# WILLOW SPRINGS RANCH FILING NO. 2

STREET  
PLAN COVER

**MOUNTAIN MUHLY DRIVE**  
**PLAN & PROFILE**

# CD\_V1 redline.pdf Markup Summary

CATTAIL DRIVE  
PLAN & PROFILE

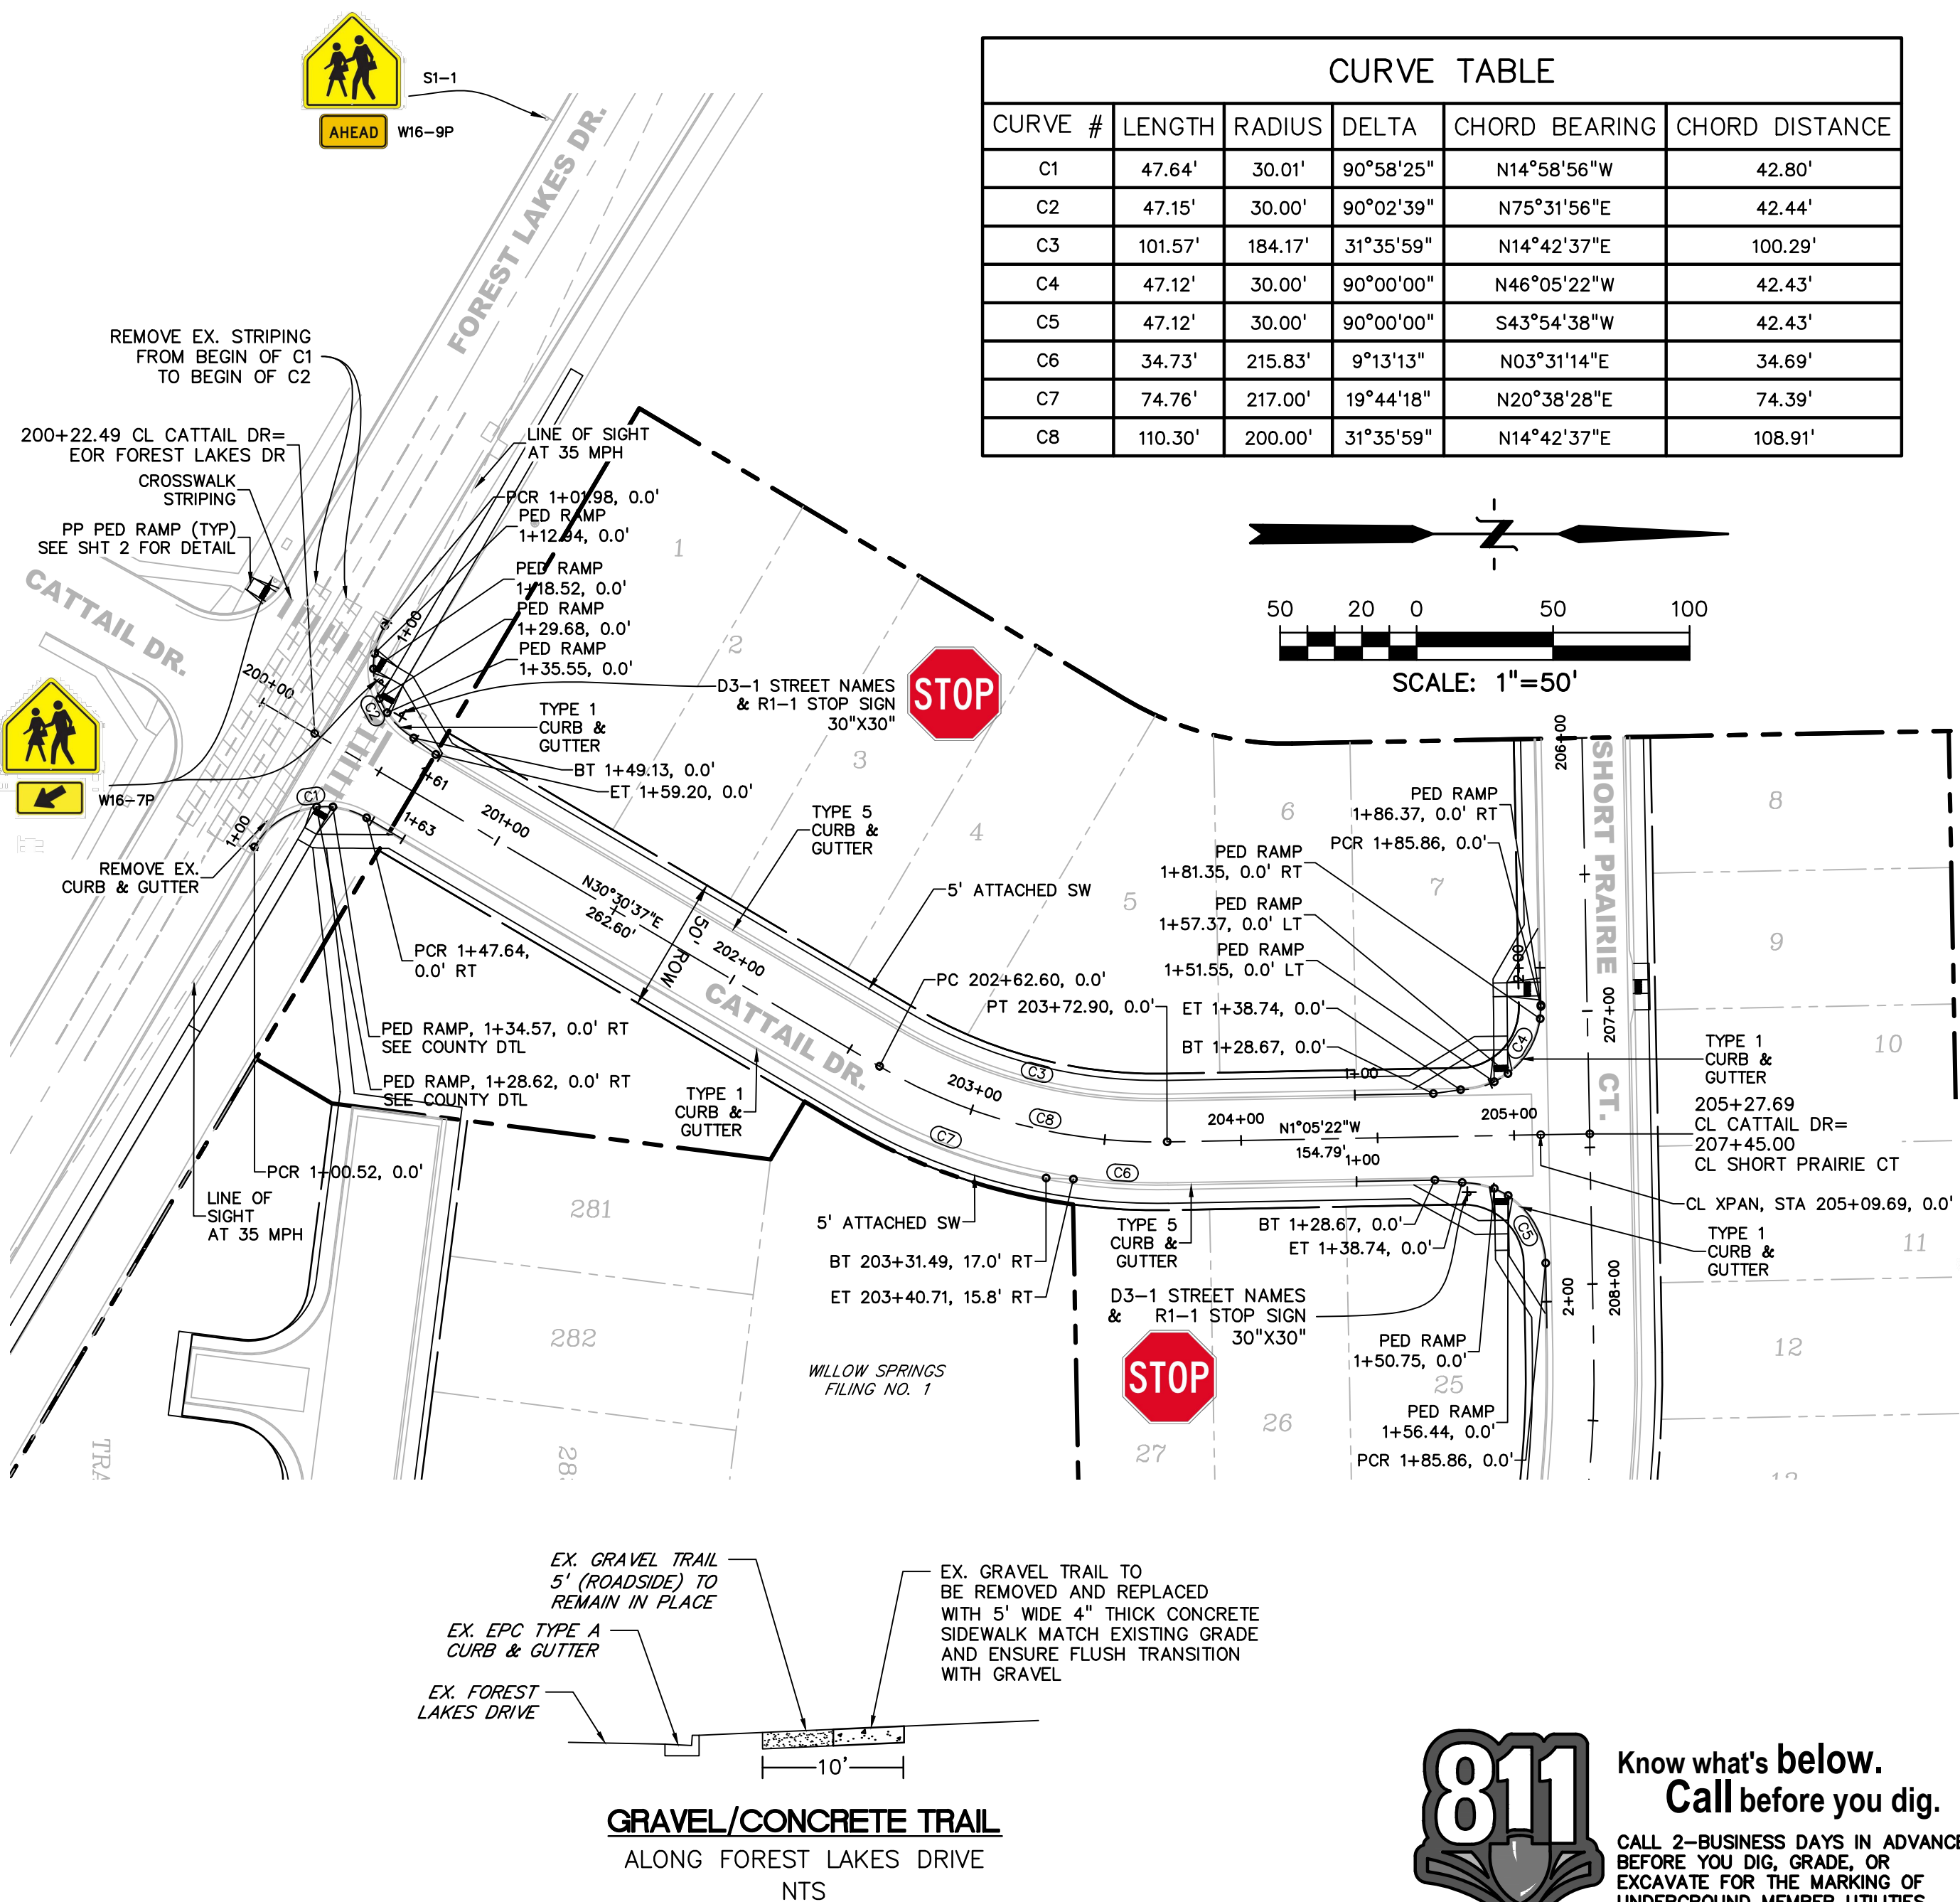
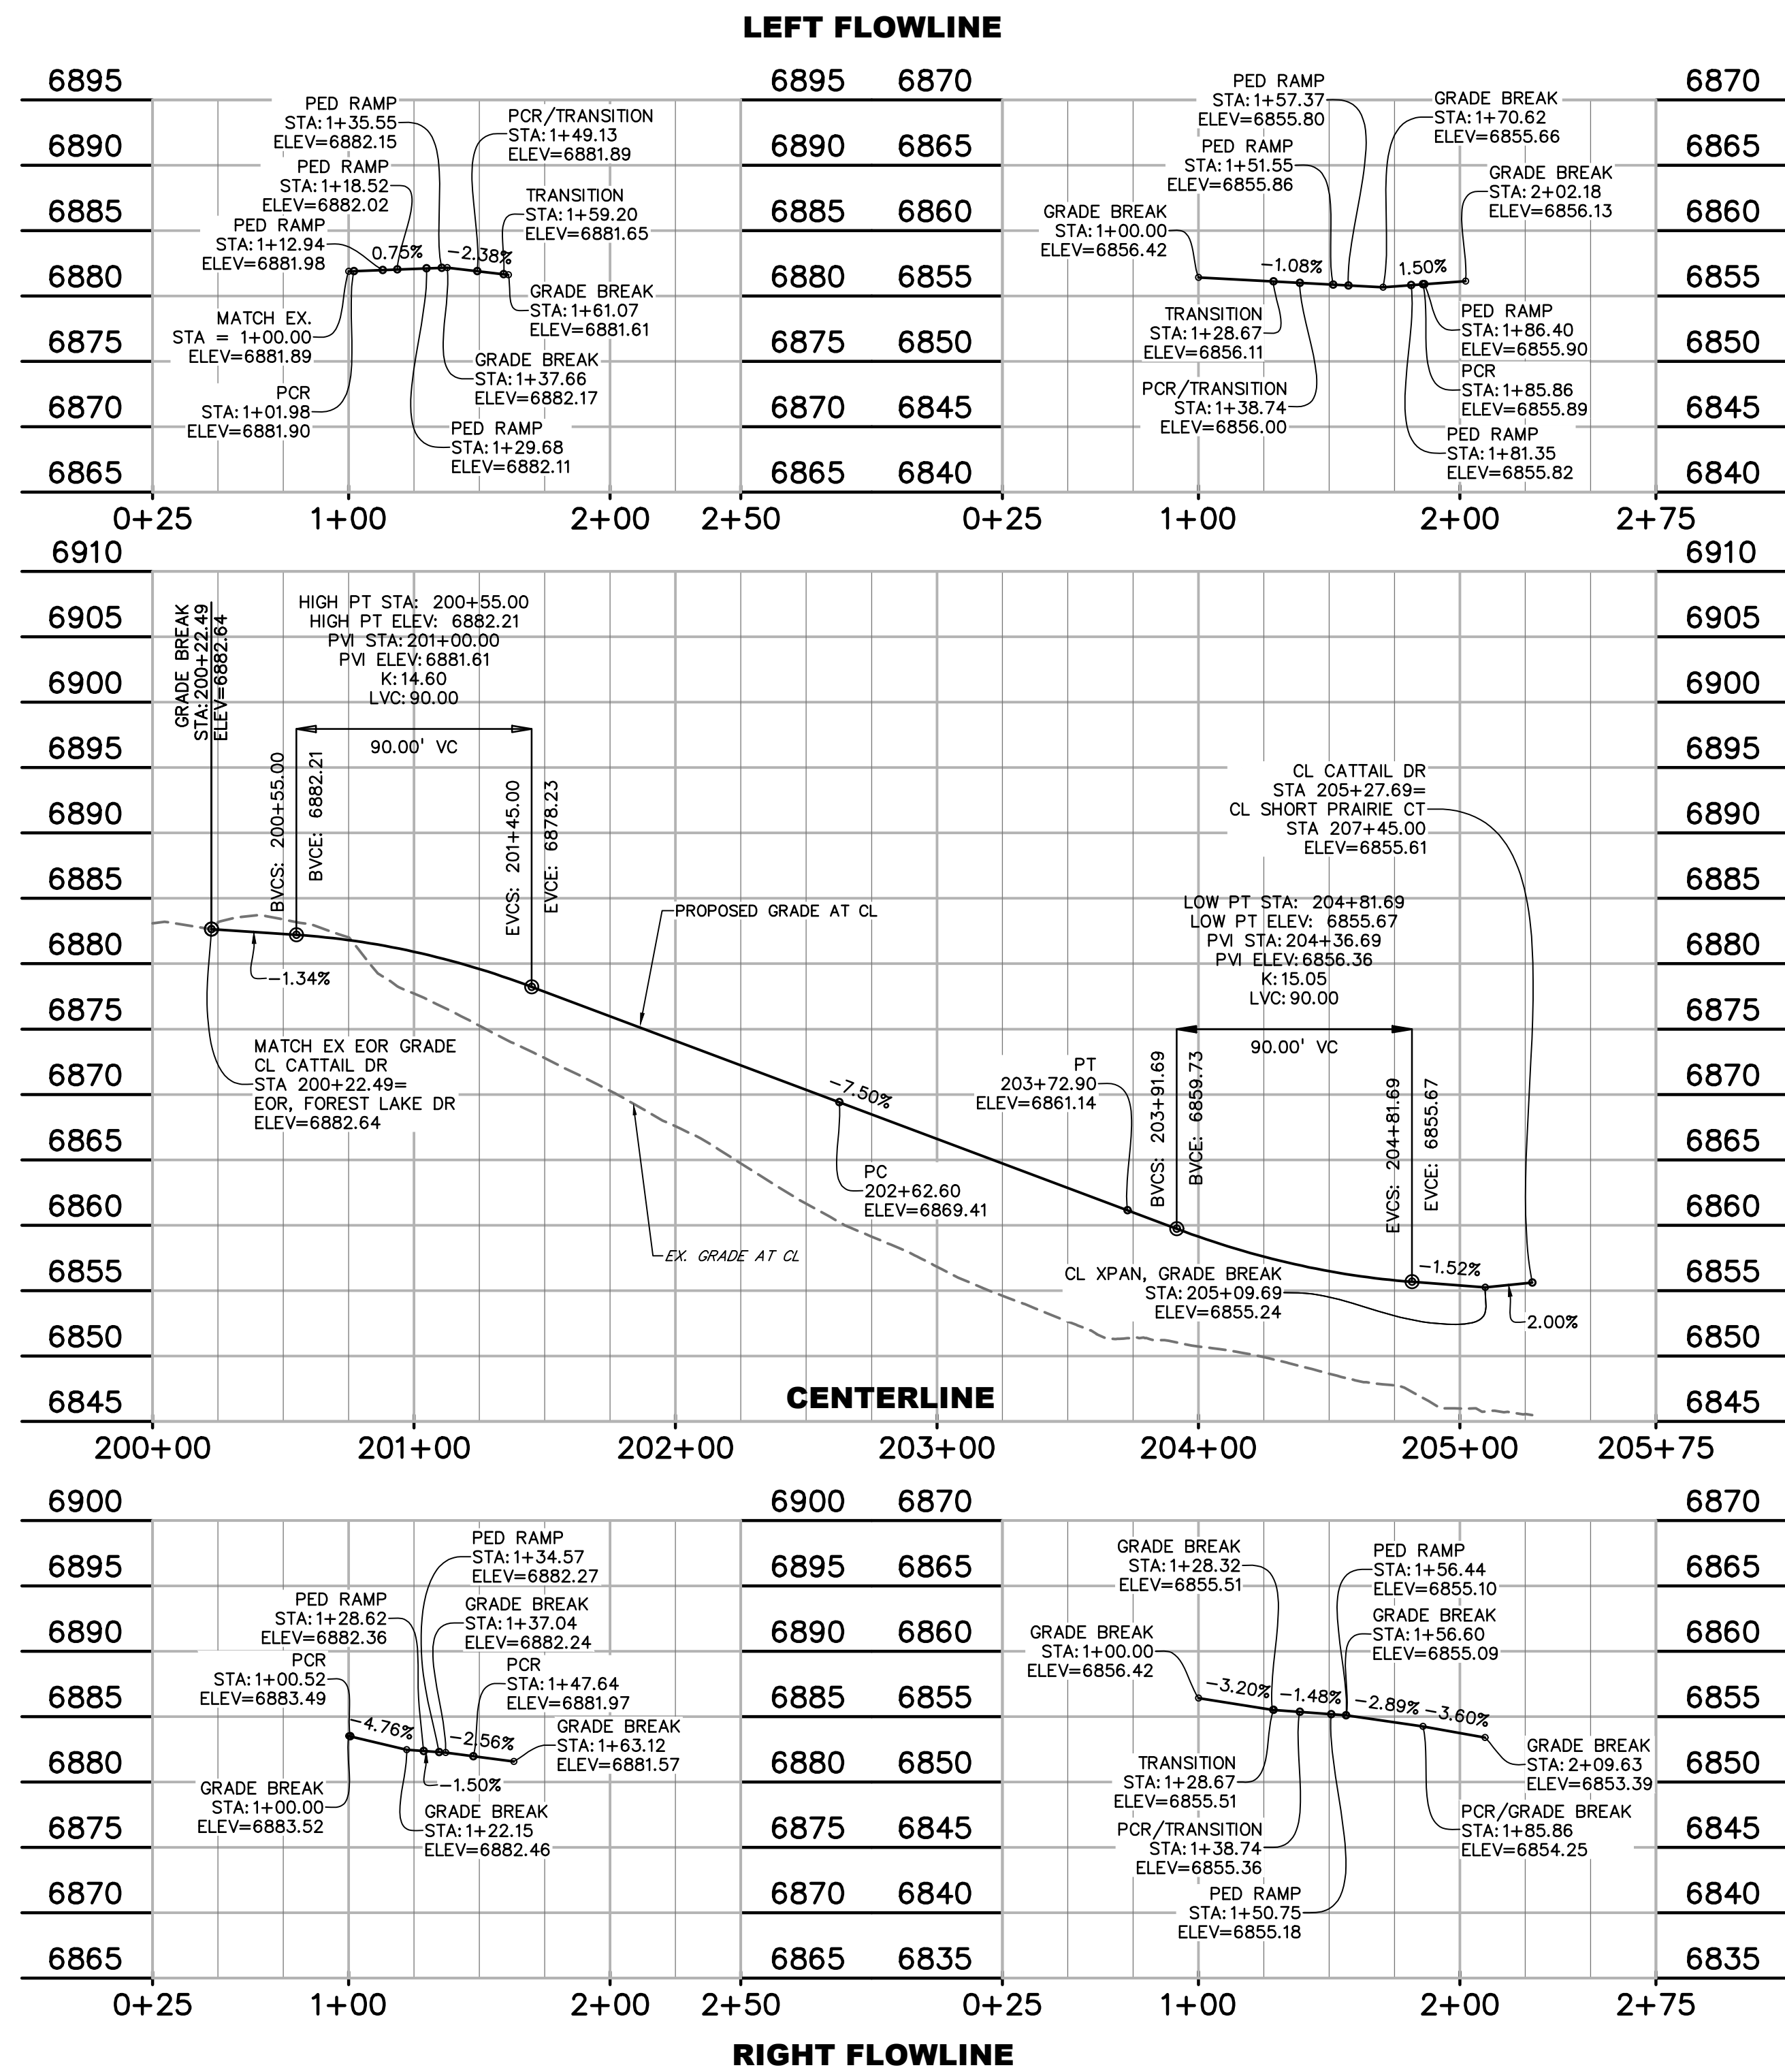
Update callout to include size of the stop sign

Update and install pedestrian ramp and crossing at the intersection (highlighted in yellow)

Update the P&P sheet to reference these details for the pedestrian ramps located within the Forest Lakes ROW.
